Subject: BL-14-00022 Curry: Additional Information Request

PARCEL 104636  
Original Area: 29.16 acres  
Decreased area by: 8.90 acres  
ADJUSTED AREA: 20.26 acres

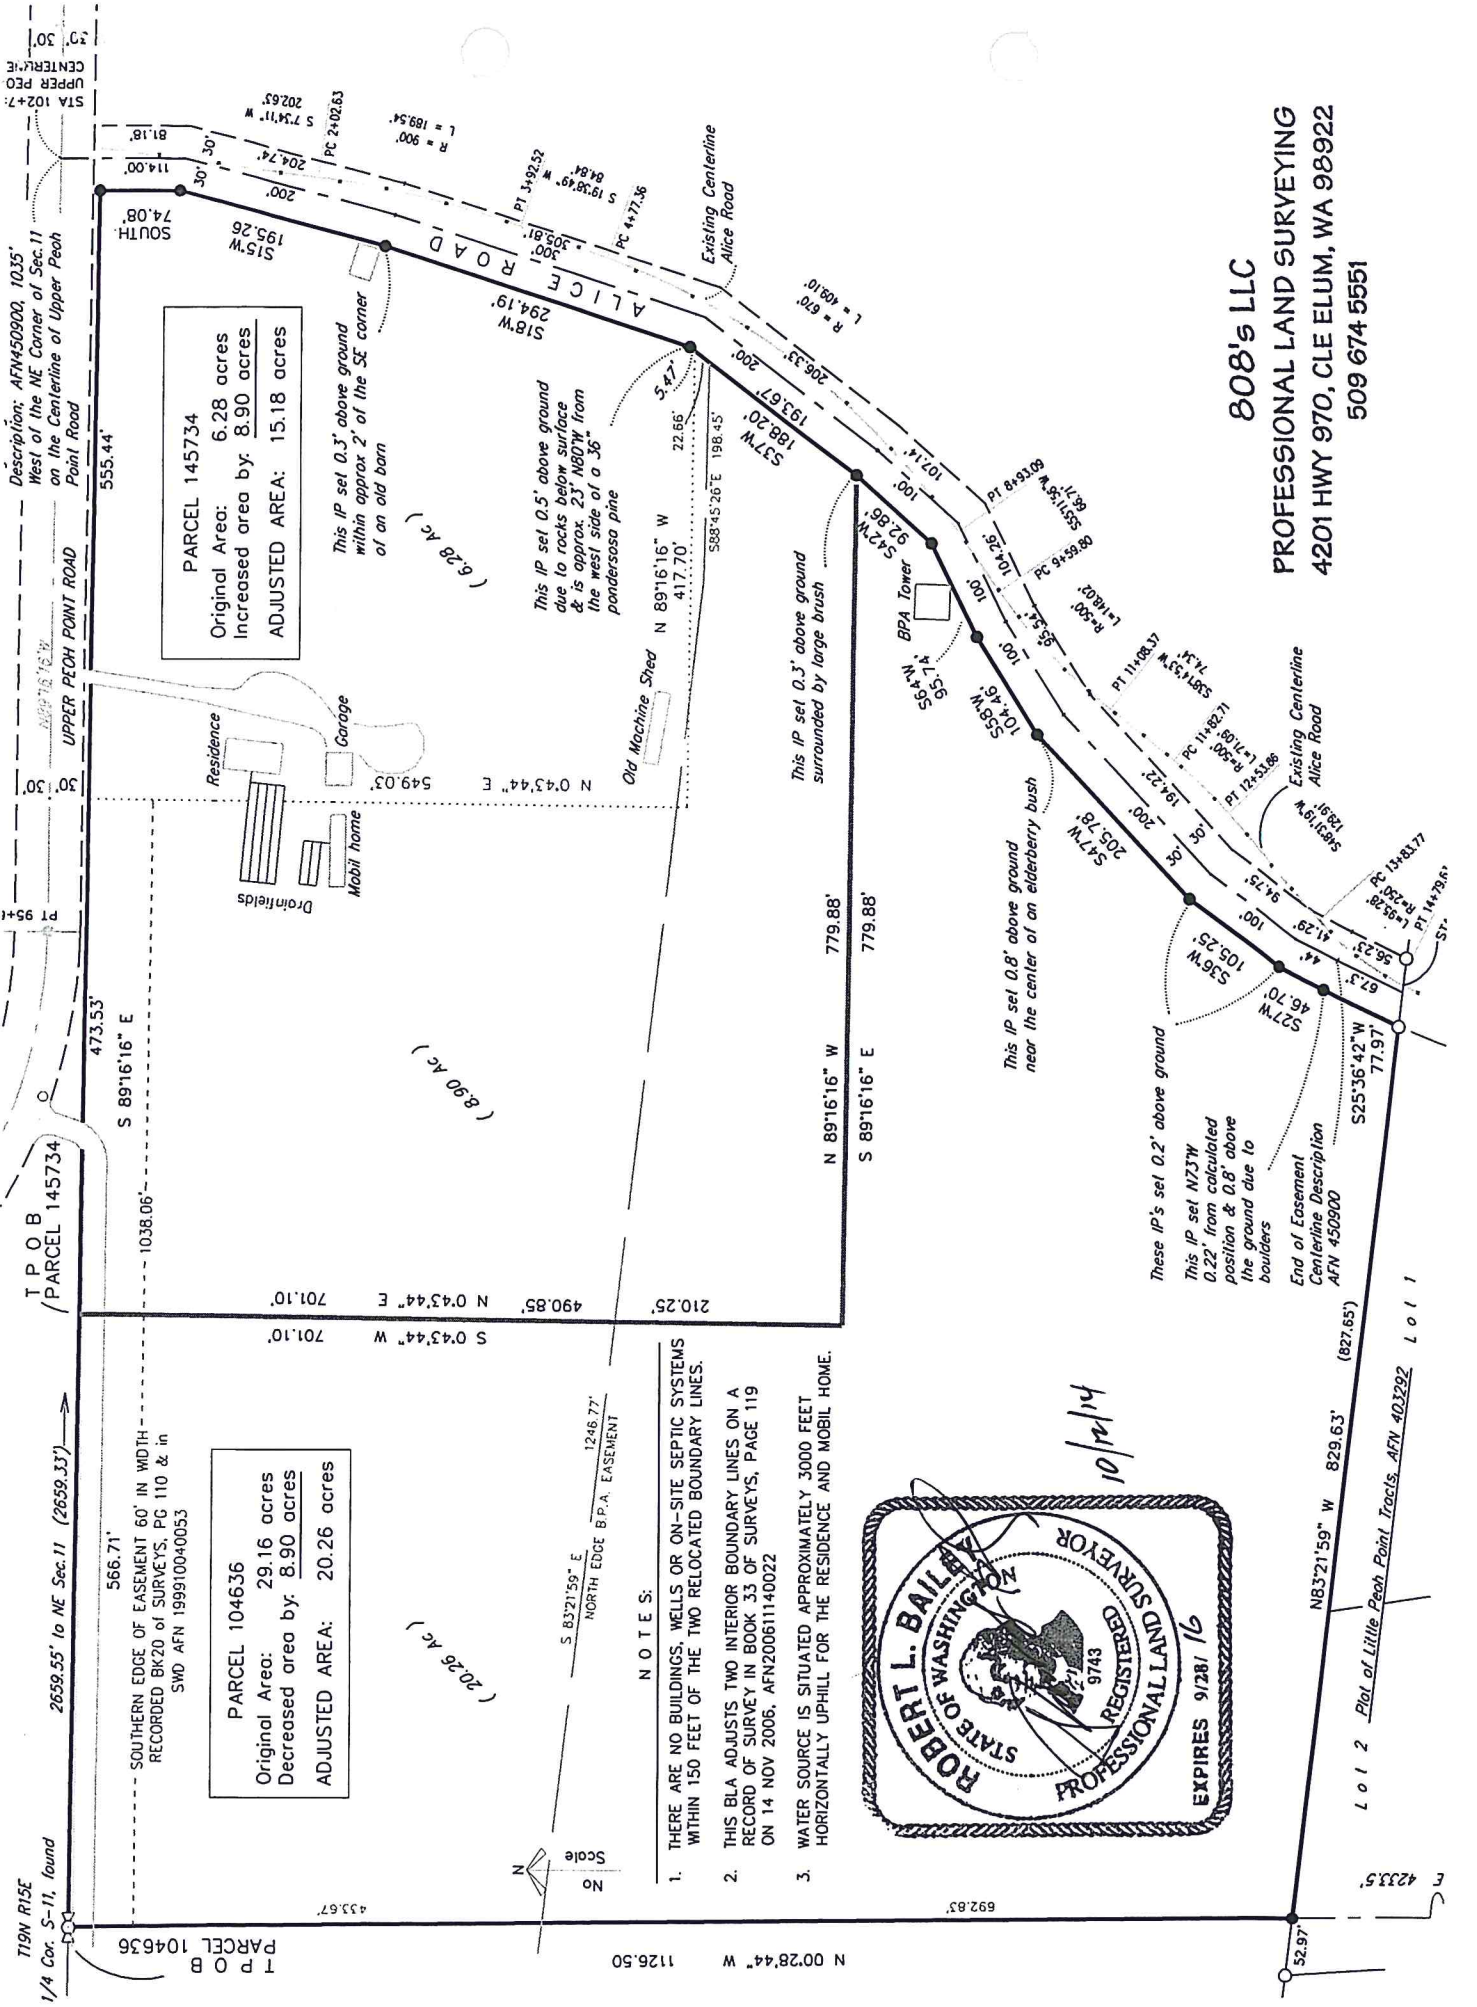
The additional information letter is in regard to the fact that you did not submit a site plan showing the *existing* configurations of the subject parcels. You did submit a site plan of the *proposed* configuration of the parcels, but as it states directly on the BLA application a site plan of the existing parcels/ lot lines needs to be submitted for a complete application.

The only thing I don't see is the location of any well on either parcel. Otherwise these will work fine.

1. There are no wells on either of the parcels owned by the Curry estate for which a boundary line adjustment is requested;
2. The septic system drainfields are clearly delineated on the survey map drawn by Mr. Bailey that was submitted with the original application. I attach a copy for your ease of reference; please see page 8 of the application for the referenced map. As you will see, the septic system/drainfields are located immediately west of the residence and north of the structure labeled "mobil home."
 - a. Note 1 of Mr. Bailey's notes on the map reflect that no wells or septic systems are located within 150 feet of the adjusted boundary lines.
 - b. Note 3 of Mr. Bailey's notes on the map describes the location of the water source for the property

There is no well on either property. Mr. Bailey also made a note of that on his drawing. The primary source of water for the house is from a spring on a property south & slightly east of these properties. Access is protected through an easement supporting access for purposes of the water right.
